BSK INVESTMENTS
SITE DEVELOPMENT PLAN
EL PASO COUNTY, COLORADO

Add PCD File #
PPR 19-024

11/08
DebG
revised
03-14-2019
DebG

BSK INVESTMENTS
LIGHTING AND LANDSCAPE PLAN
EL PASO COUNTY, COLORADO

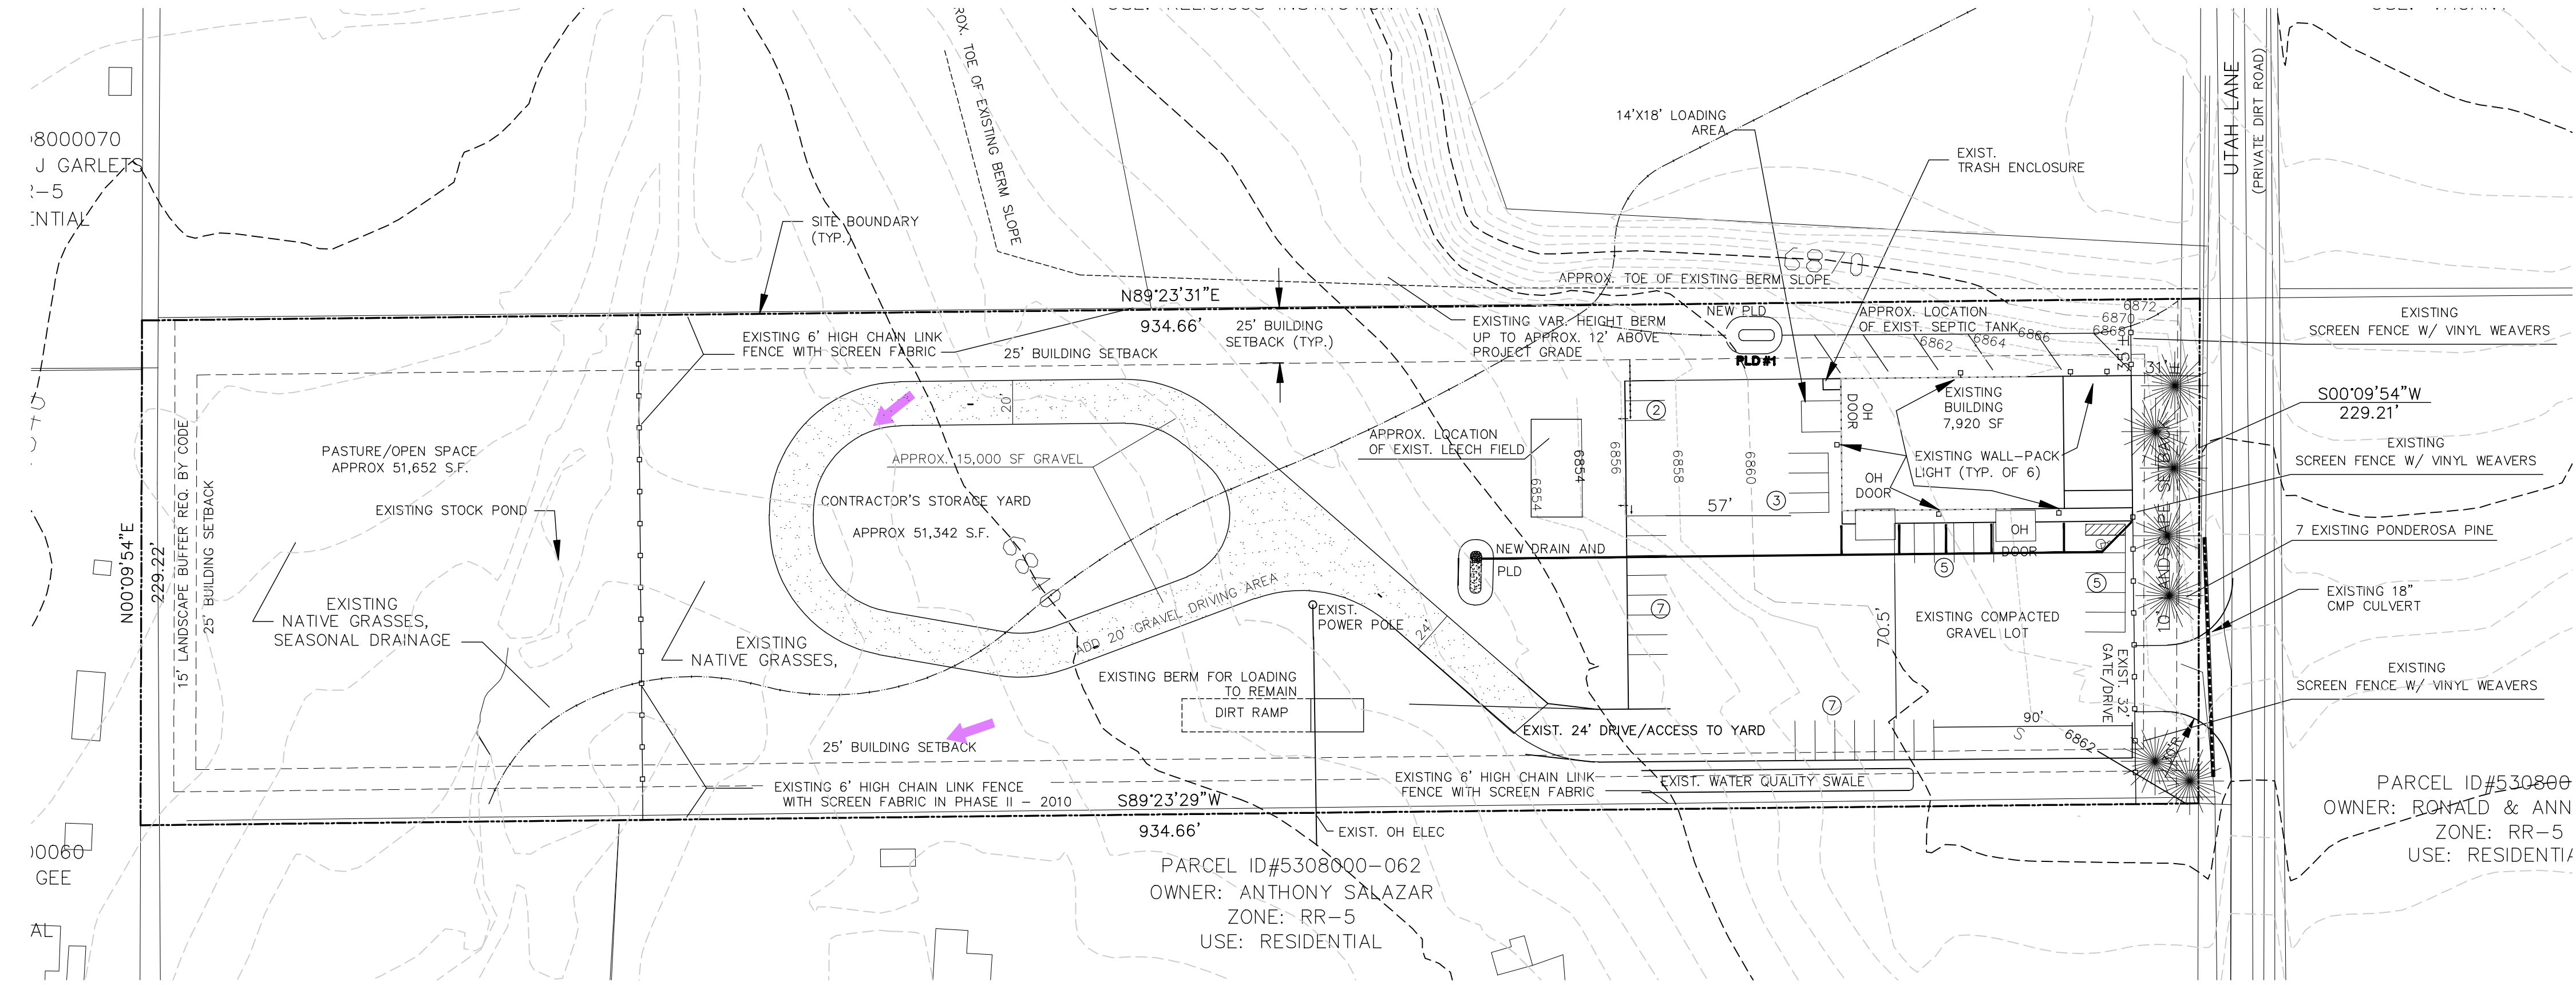
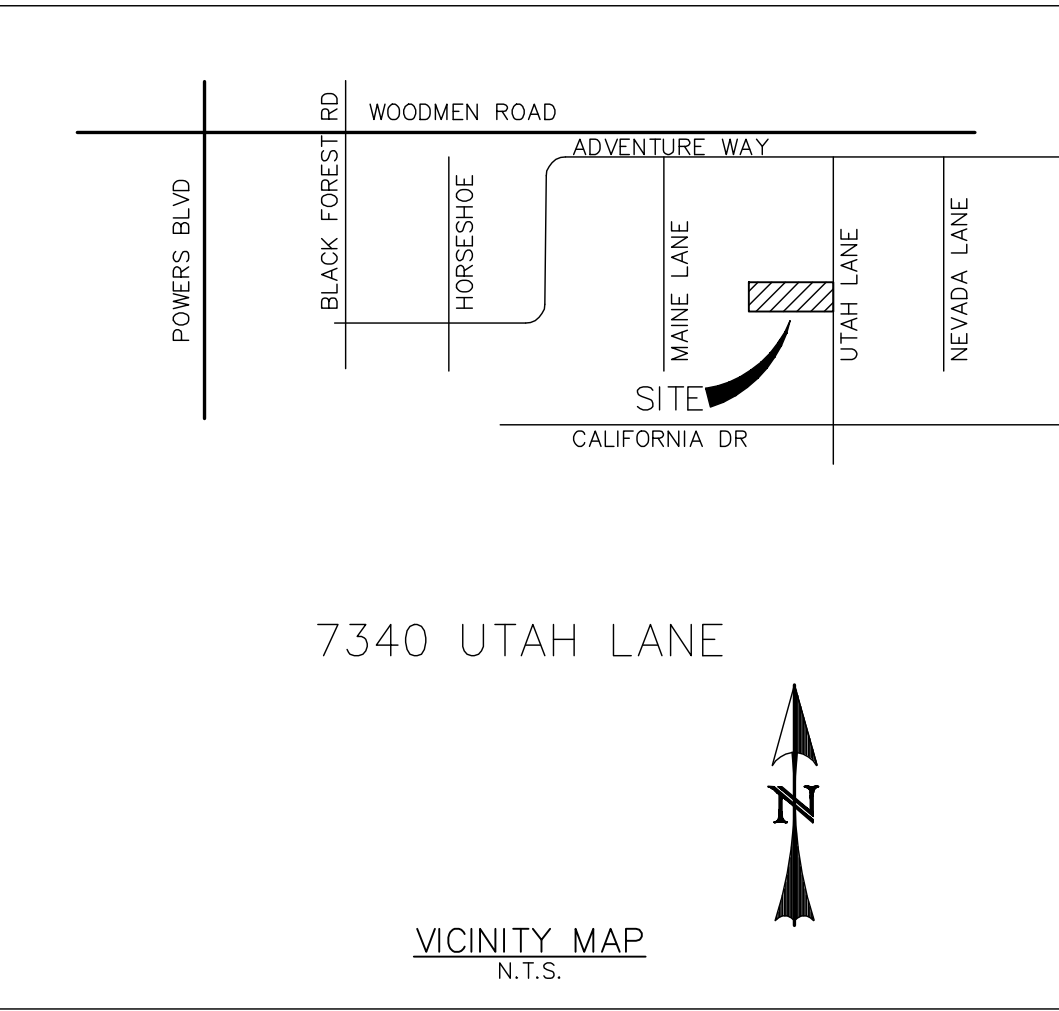
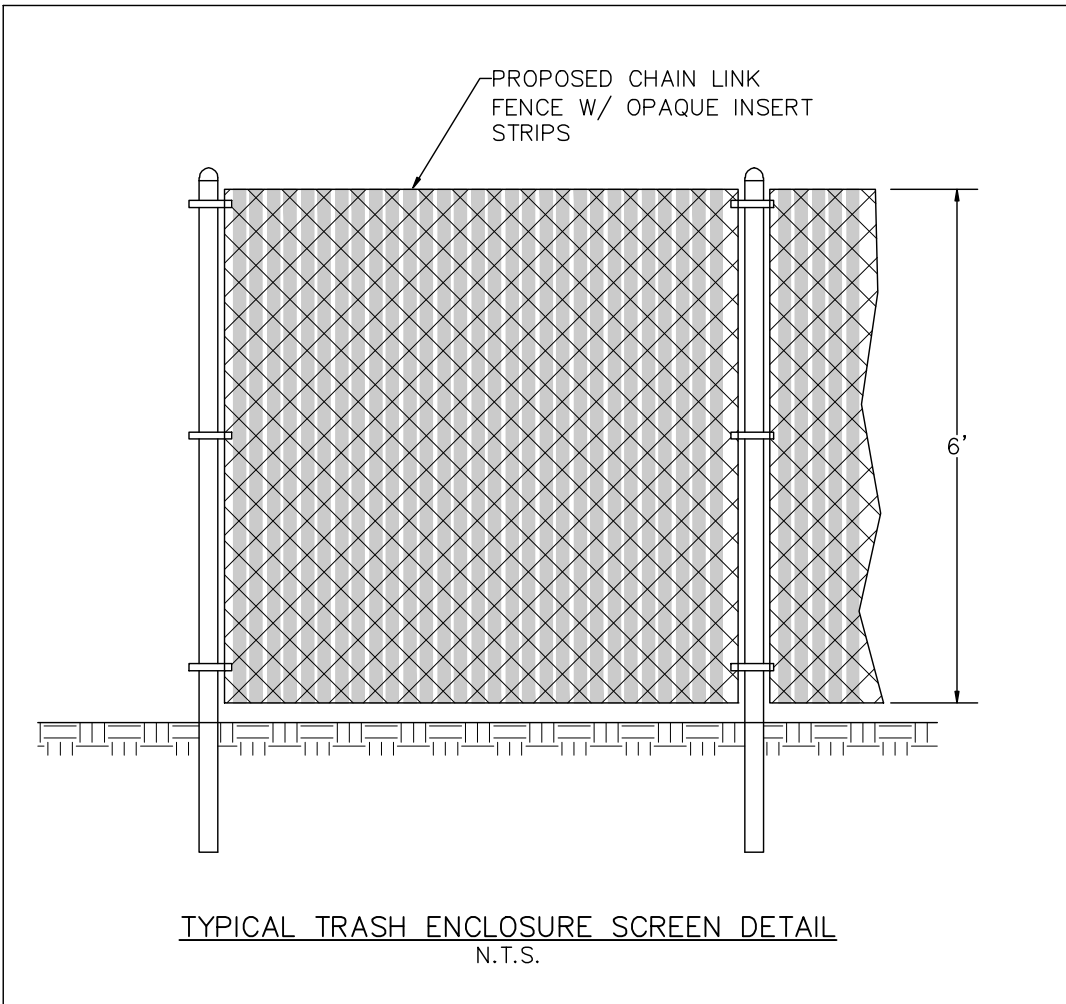
Label this PLD.
Label both PLDs as proposed.

Outline the boundary of the contractor storage yard area. If it is within the gravel driving area, it appears that the total area of the gravel driving area and the storage yard is 28,064 sf.

Label the accessible path of ADA accessible exterior routes per LDC 6.1.3(C)

This does not appear to match the ADA detail on the landscape sheet with the larger access aisle.
